Office of
Environment
& Heritage

DOC18/819332
SSD-9511

CFC Large format retail, Bringelly Road, Horningsea Park (SSD 9511) - Environmental Impact Statement

Attachment A

DRAWING TITLE
LANDSCAPE OVERALL PLAN

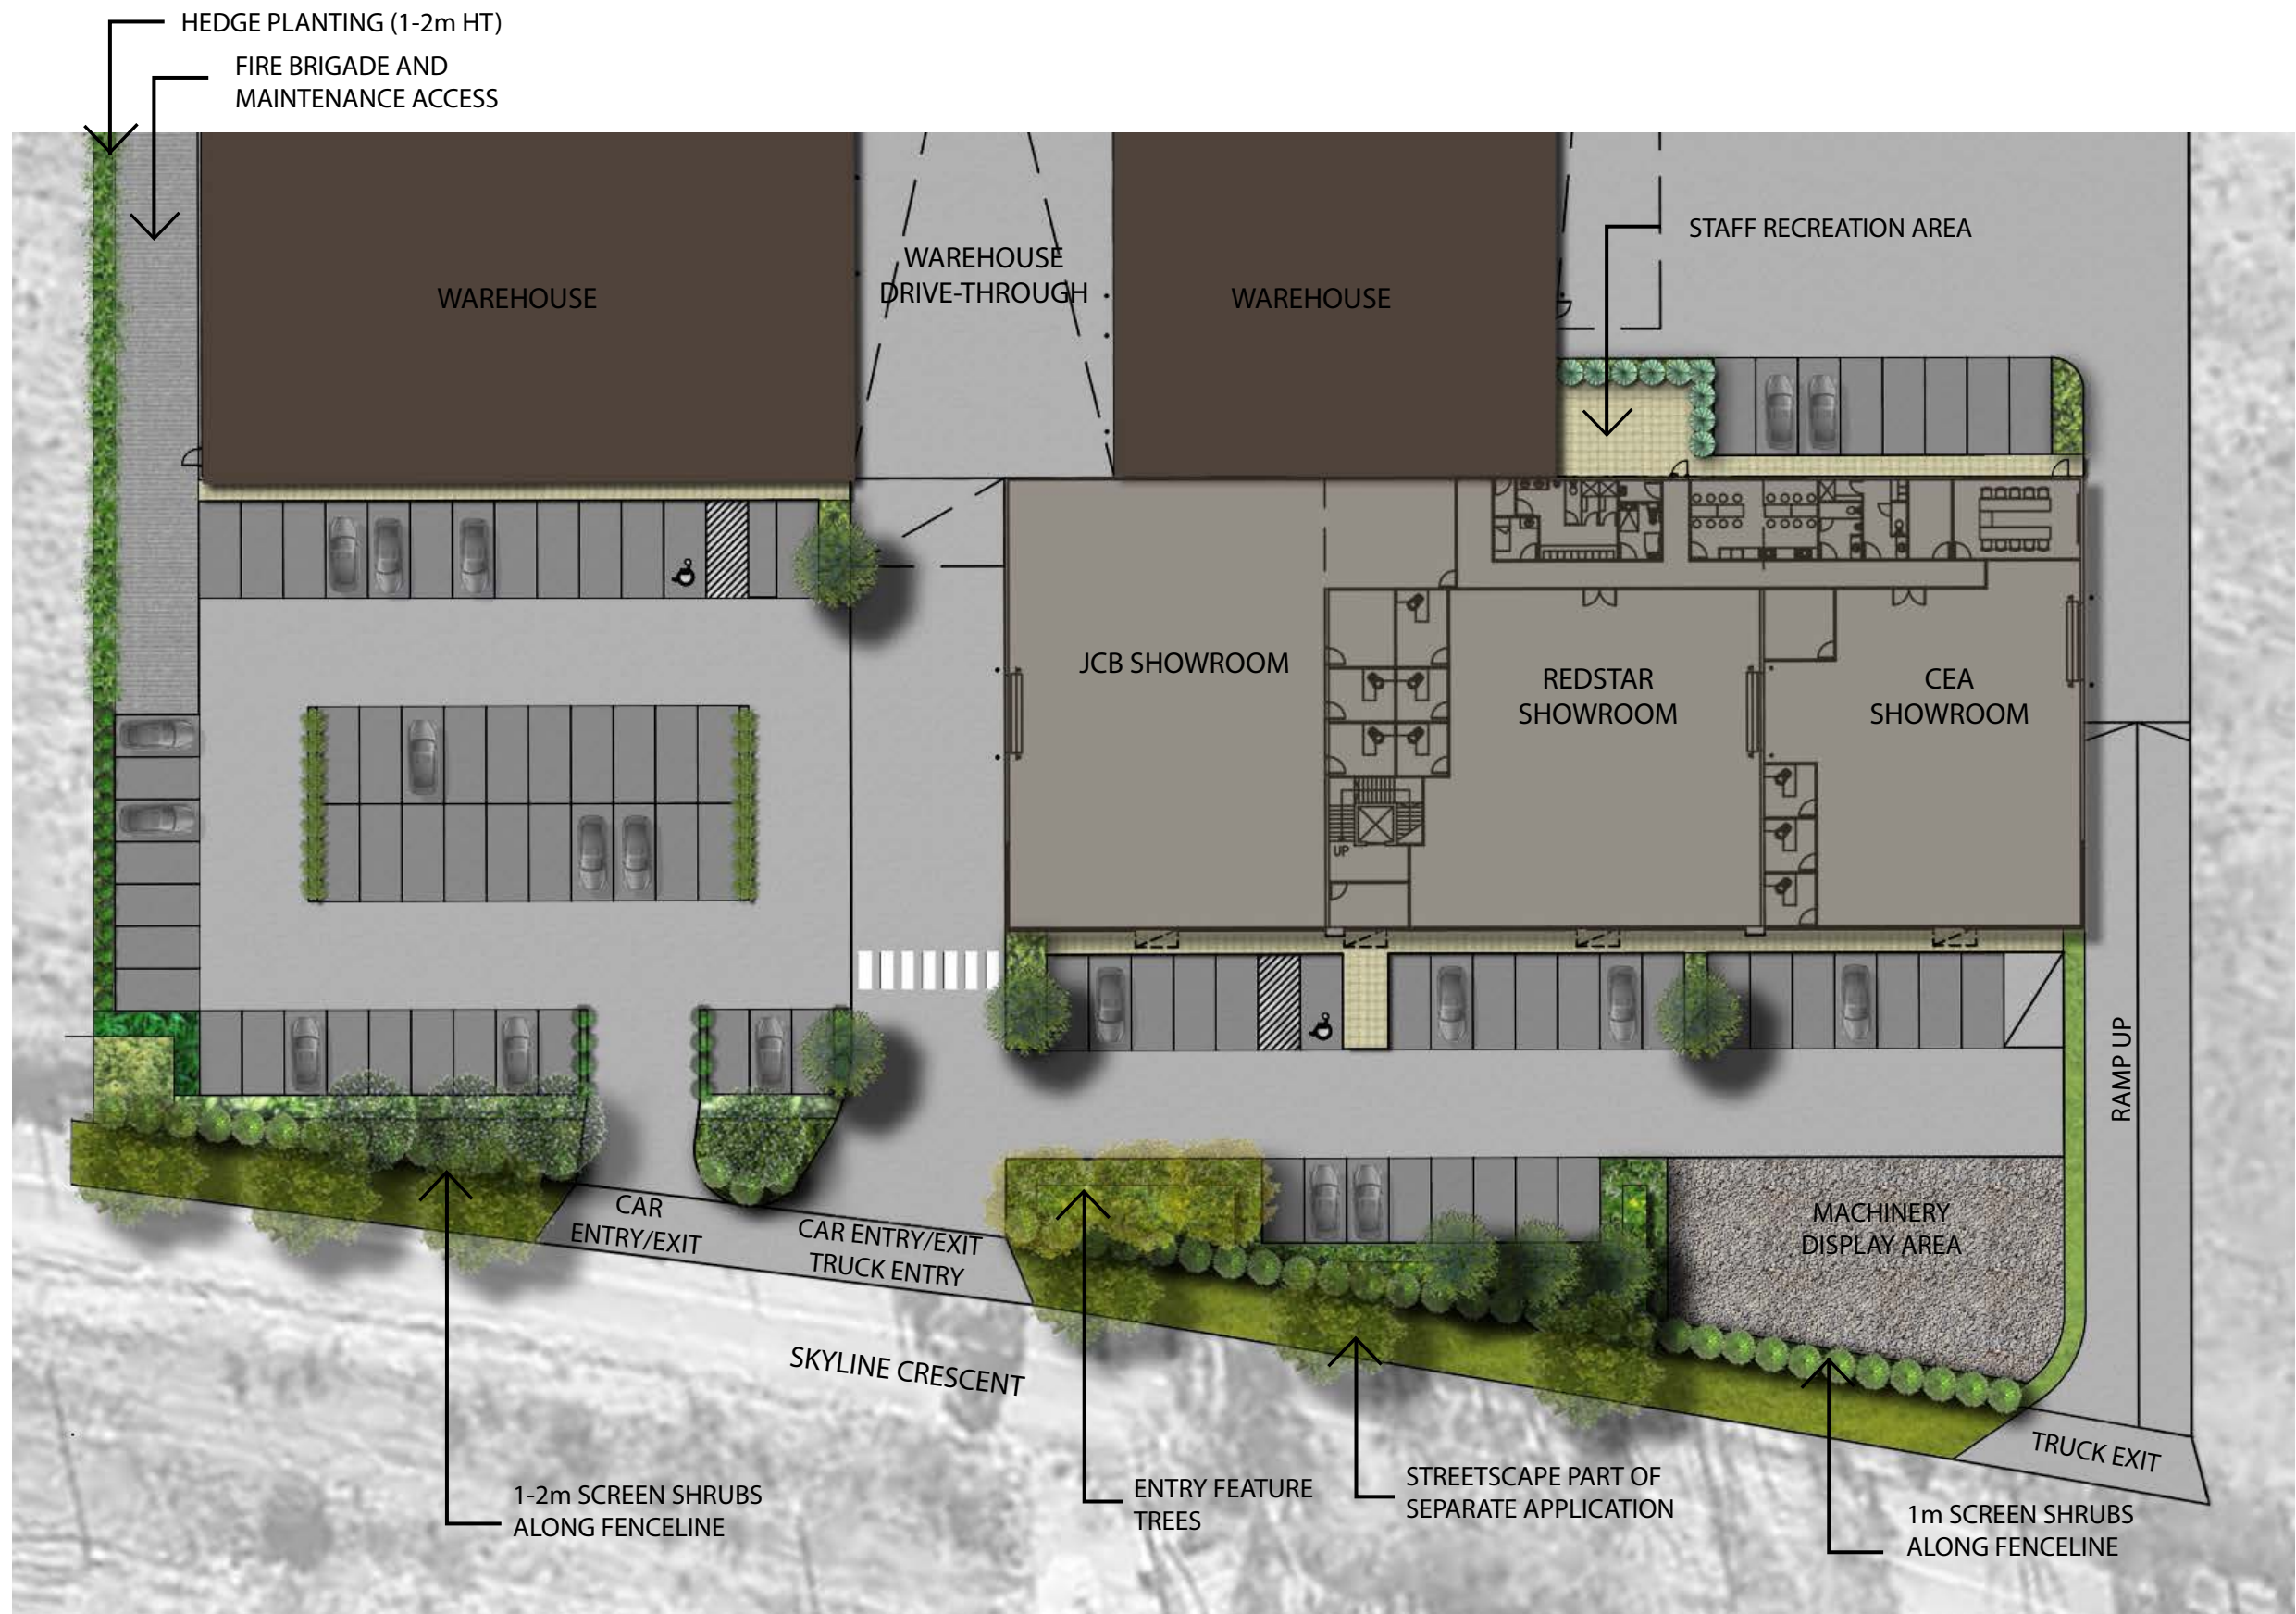
OEH notes the Landscape Plan proposes to plant the following native trees *Eucalyptus moluccana*, *E. tereticornis* and *Corymbia maculata*. OEH supports the proposed use of these local native species at the site and recommends the landscaping uses a diversity of native plant species from the relevant local native vegetation community (or communities) that once occurred on the site to improve local biodiversity. The use of local genetic plant material has numerous environmental benefits.

If the development is approved OEH recommends the following is included as a condition of consent:

- 1) A diversity of native trees, shrubs and groundcover species from the relevant local native vegetation community (or communities) that once occurred on the site shall be used to landscape the site including street planting.
- 2) The street planting shall use advanced and established local native trees preferably with a minimum tree height of 2-2.5 metres and /or plant container pot size of 50-75 litres.
